TOWN AND COUNTRY PLANNING ACT 1990

APPROVAL REQUIRED BY CONDITION OF PERMISSION

Reference:	H07-0311-24	Date of Decision:	18th June 2024
Applicant:	Mr A Zdroba 32 Hillgate Gedney Hill Spalding PE12 0NN		
Location:	32 Hillgate Gedney Hill Spalding		
Description:	Details of landscaping, foul water disposal and soakaway system for disposal of surface water (Conditions 3, 11 and 12 of H07-0815-20)

Project:	Detached Garage
Client:	Rebeca Zdroba
Address:	32 Hillgate Gedney Hill Spalding PE12 0NN
Drawing Title:	Location Plan & Block Plan
Dwg No:	04
Scale:	1:500 & 1:1250 @ A4
Date:	Mar 2020

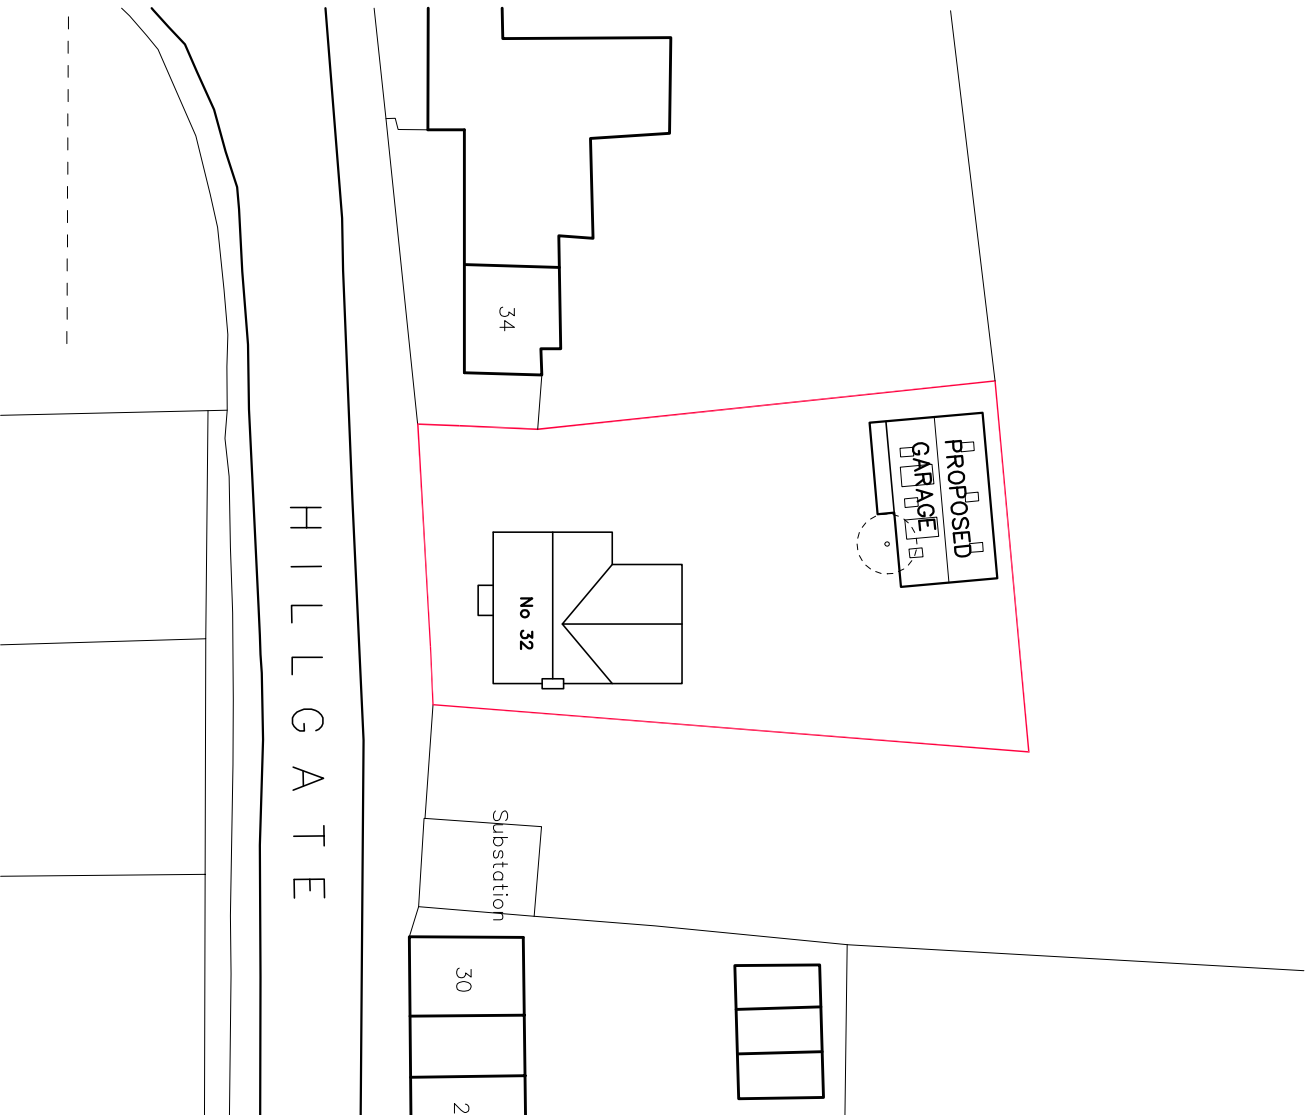
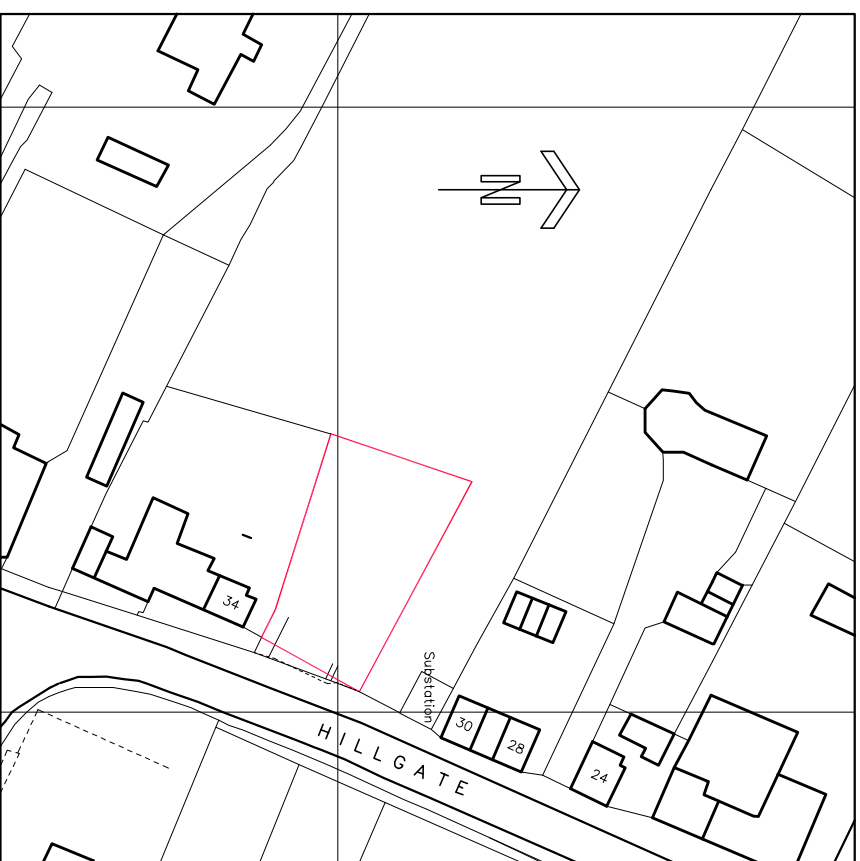
- 1 In the opinion of the Local Planning Authority the information submitted does not satisfactorily demonstrate that the proposed foul and rainwater systems are viable without increasing flood risk on or adjacent to the site.

- It will need to be satisfactorily demonstrated that the rainwater soakaways are sized accordingly based on the results of a percolation test carried out in that area of the plot.
- The attenuation tank should be kept a minimum 5 metres from any building and a minimum 2.5 metres from the boundary.
- The outlet from the treatment plant should preferably be to the drainage ditch, not a soakaway. If the site has been excavated and replaced with hardcore, a drainage field will not work adequately.
